Lead Local Flood Authority
Post Point CHN 215
Hertfordshire County Council
County Hall, Pegs Lane
HERTFORD SG13 8DN

Date 05 August 2020

RE: 6/2020/1463/FULL - 1 Maynard Place Cuffley Potters Bar EN6 4JA

Proposed Block Plan
1:500 @ A3

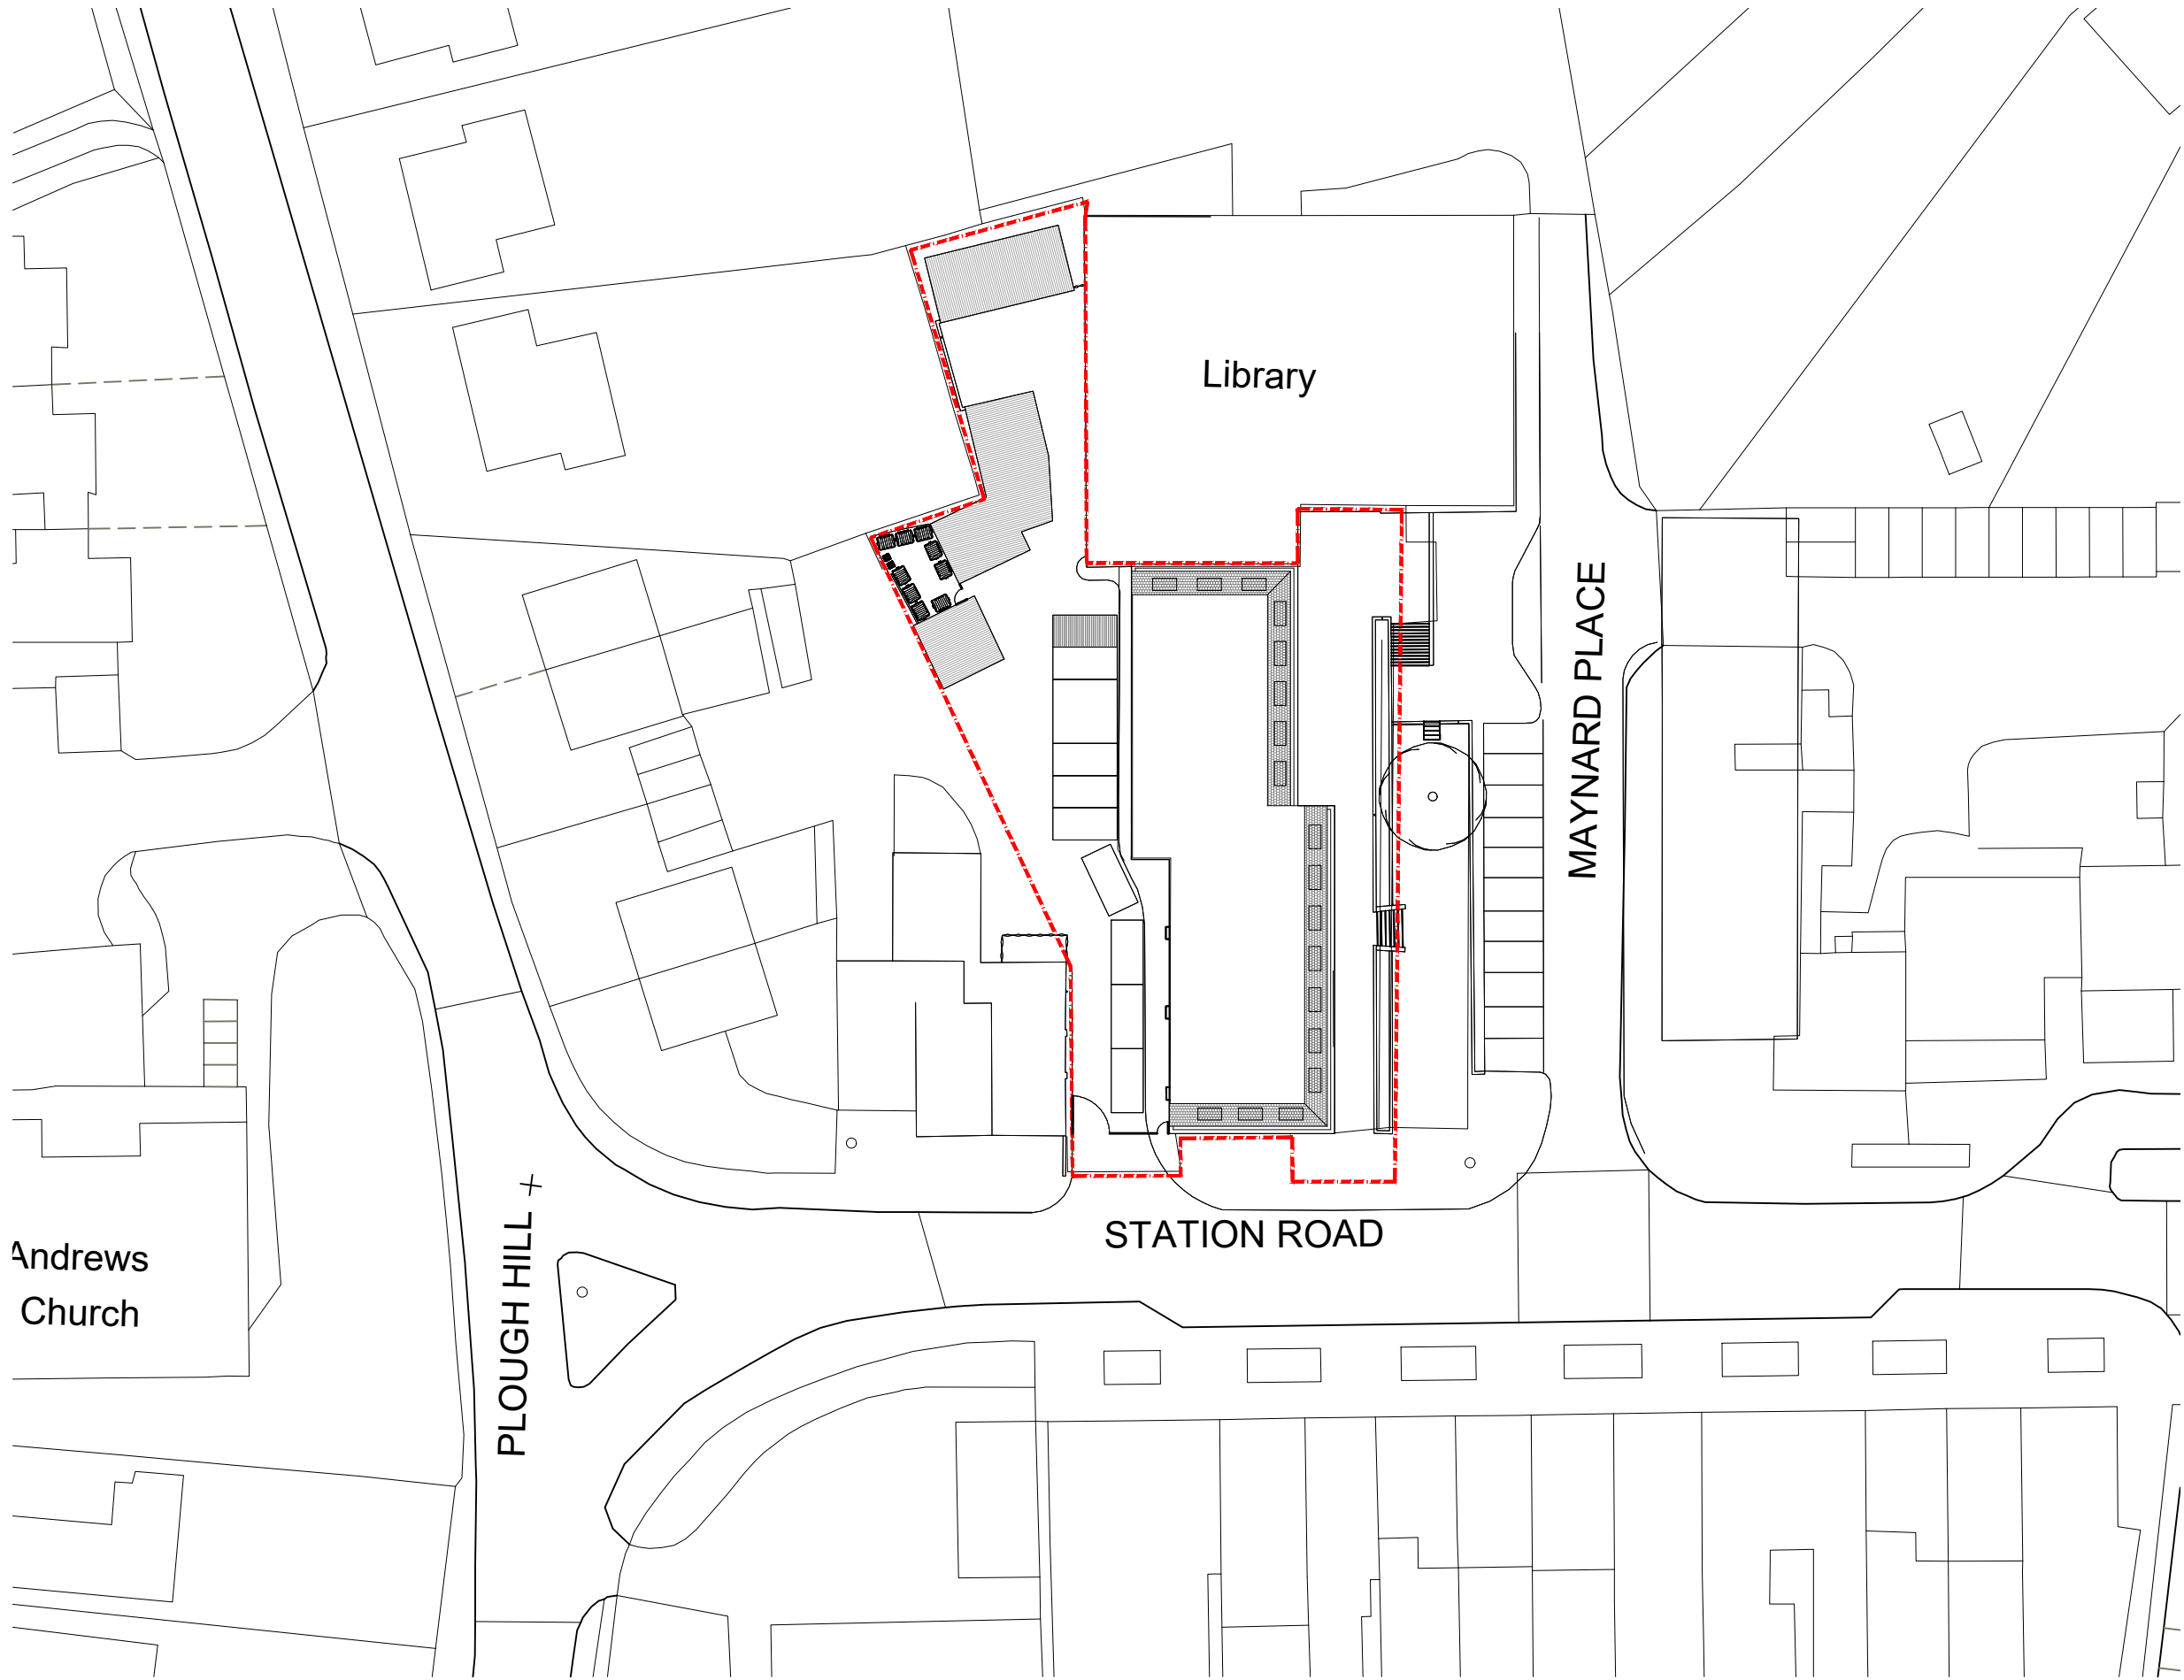
From a review of the proposed block plan (drawing reference 1254.01.002), it is shown that there is no proposed alteration to the existing footprint of the building. In addition, no new buildings or structures are proposed as part of the development.

As we understand that there will be no material change to the footprint of the building, we have no further comments to make.
